CITY OF ALBUQUERQUE

January 8, 2016

Re: Dunkin Donuts
2301 Juan Tabo Blvd., NE
Traffic Circulation Layout
Engineer's/Architect's Stamp dated 1-6-16 (H21-D051)

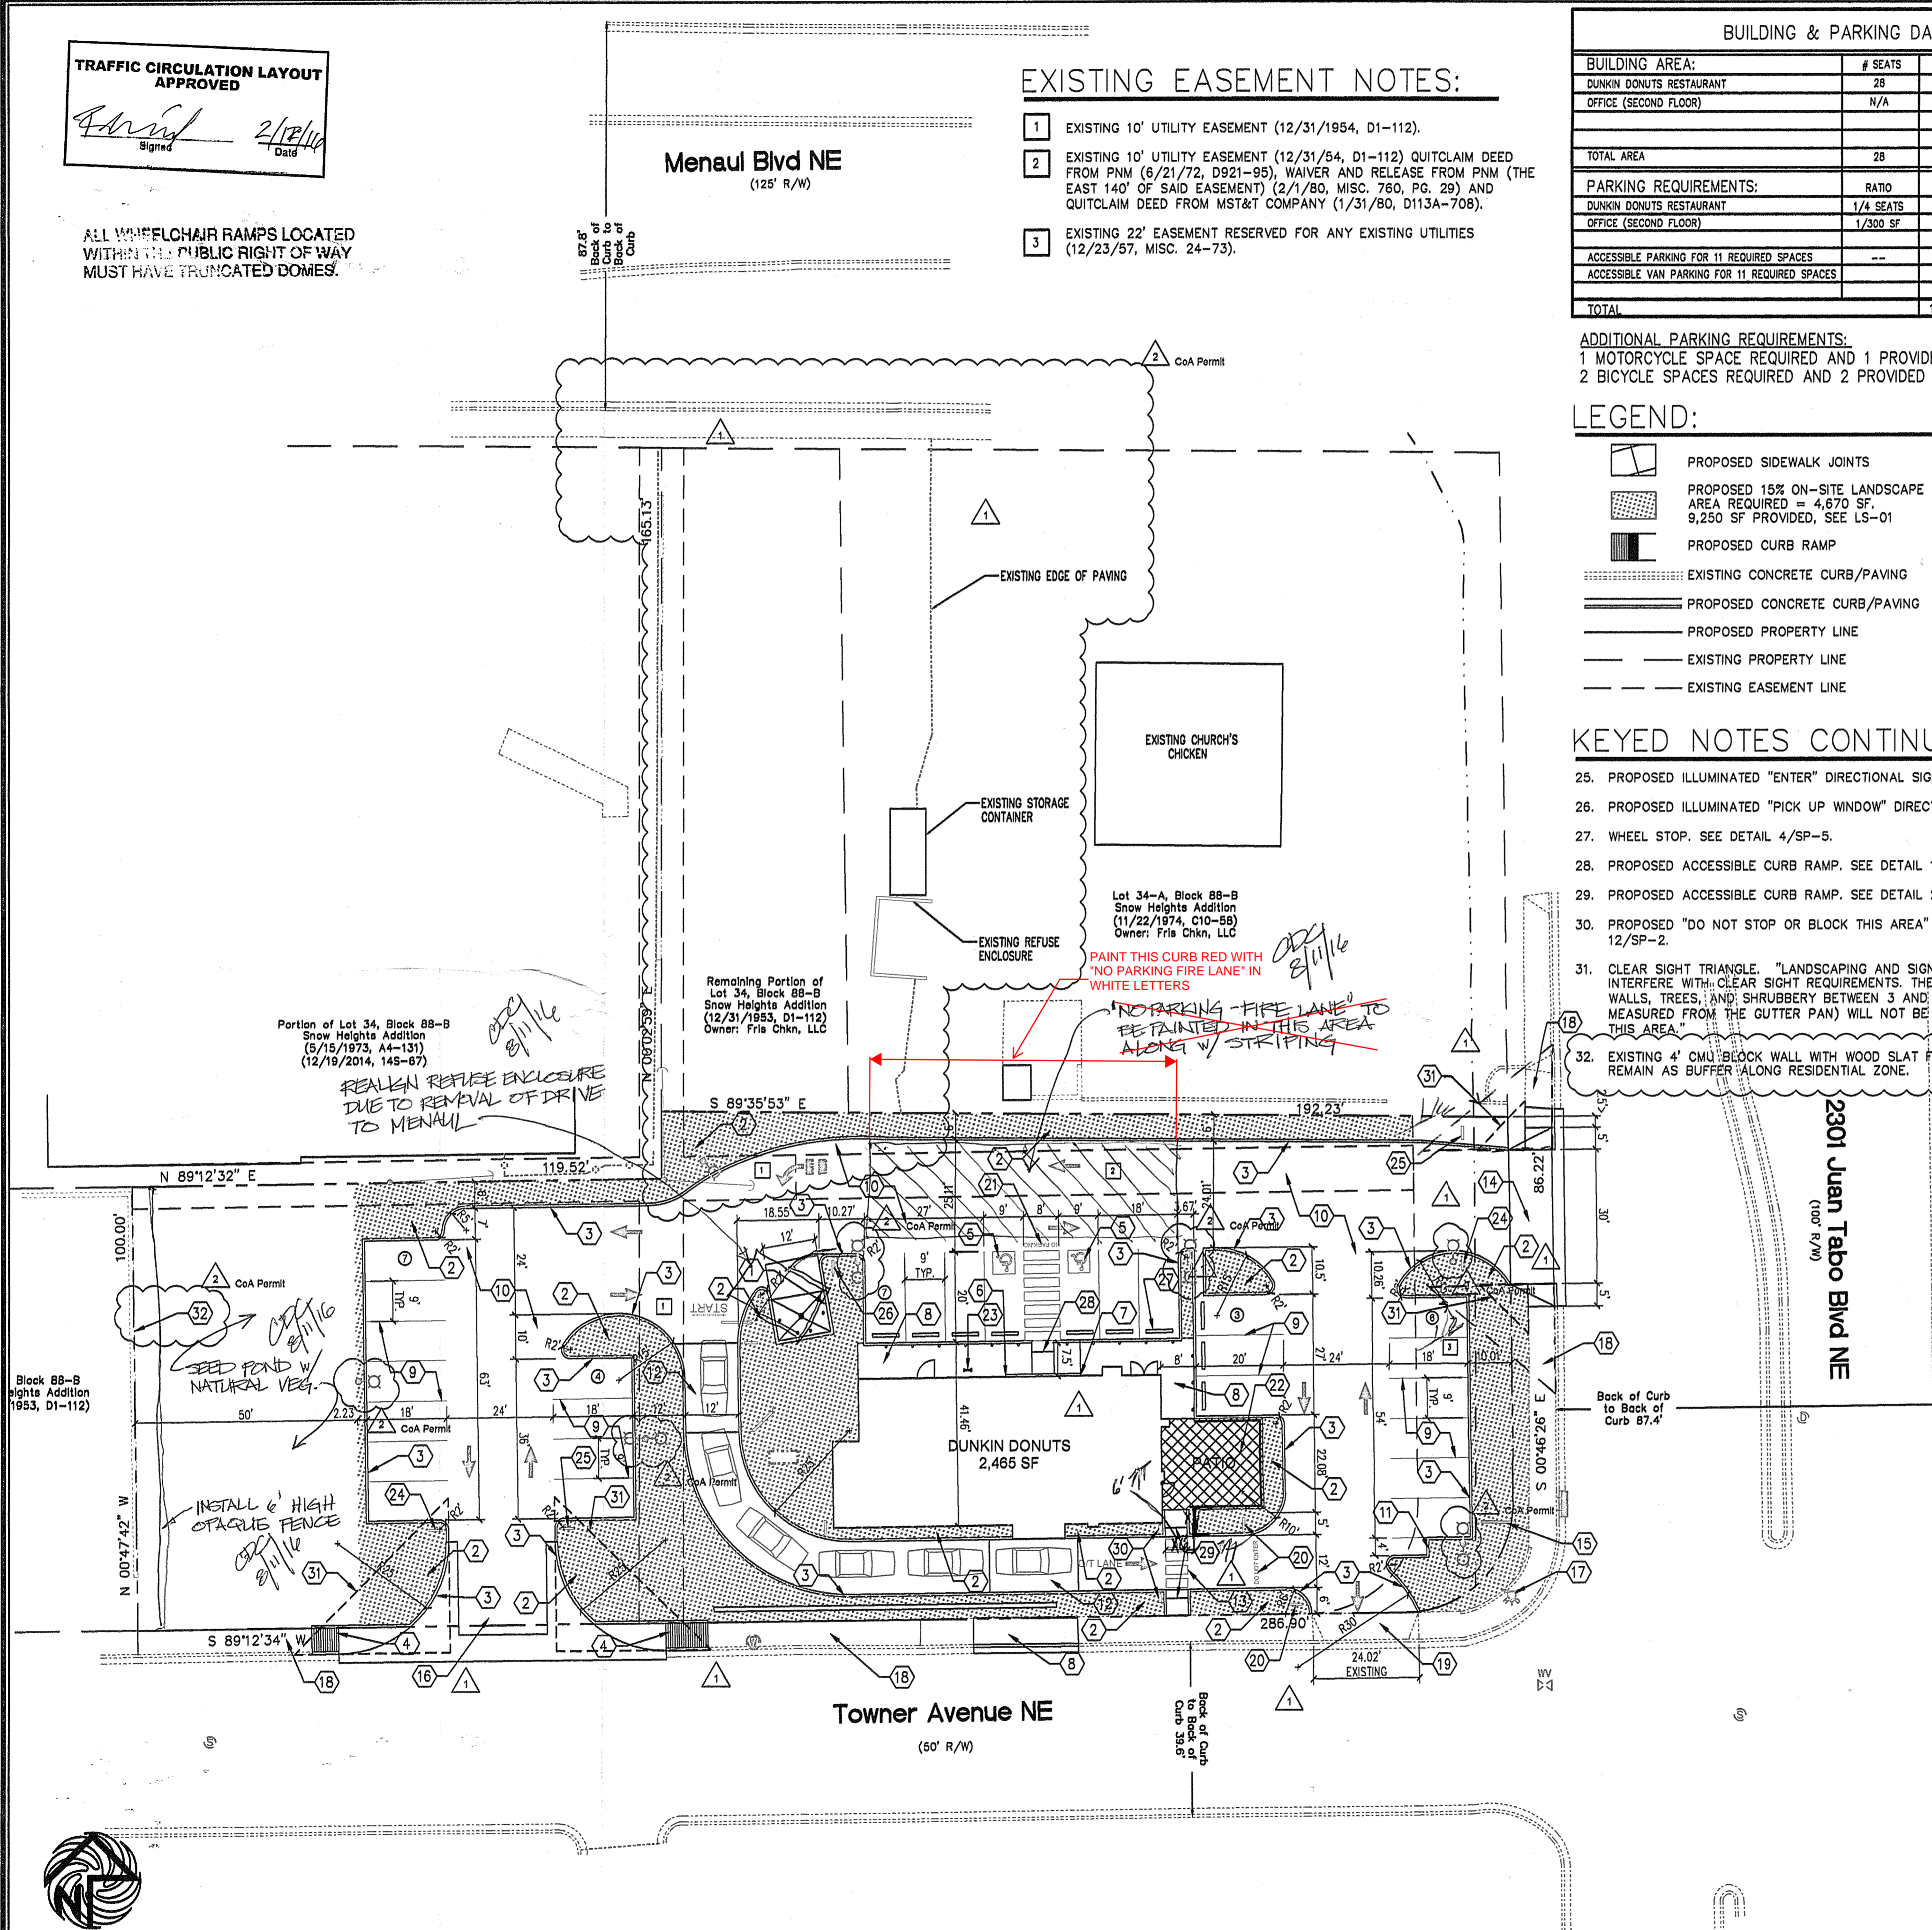
1. Please dimension and detail all existing sidewalks, right of ways and ADA access ramps per COA standard drawing. Please attach Site Detail Sheet.
2. Per the DPM, a 6 ft. wide ADA accessible pedestrian pathway is required from the public sidewalk to the building entrances. Please add sign at the south side of building at the end of the Drive Thru and before the ADA pedestrian crossing to building entrance informing vehicles to not stop or block this area.

3. Per the DPM, a 6 ft. wide ADA accessible pedestrian pathway is required from the HC parking stall access aisles to the building entrances. Please clearly show the sidewalk dimension.

4. Service vehicle and/or refuse vehicle maneuvering must be contained on-site; provide a copy of refuse approval.
5. One-way vehicular paths require pavement directional signage and a posted **"Do Not Enter"** sign at the point of egress. Please add sign at south east entrance off of Towner Ave.

6. Please provide a sight distance exhibit (see the *Development Process Manual, Chapter 23, Section 3, Part D.5 Intersection Sight Distance*). Please show this detail for entrances/exits at Towner Ave., Menaul Blvd., and Juan Tabo Blvd.

7. Please add the following note to the clear sight triangle: "Landscaping and signage will not interfere with clear sight requirements. Therefore, signs, walls, trees, and shrubbery between 3 and 8 feet tall (as measured from the gutter pan) will not be acceptable in this area."
8. All broken or cracked sidewalk must be replaced with sidewalk and curb & gutter. A build note must be provided referring to the appropriate City Standard drawing.
9. Please include two copies of the traffic circulation layout at the next submittal.
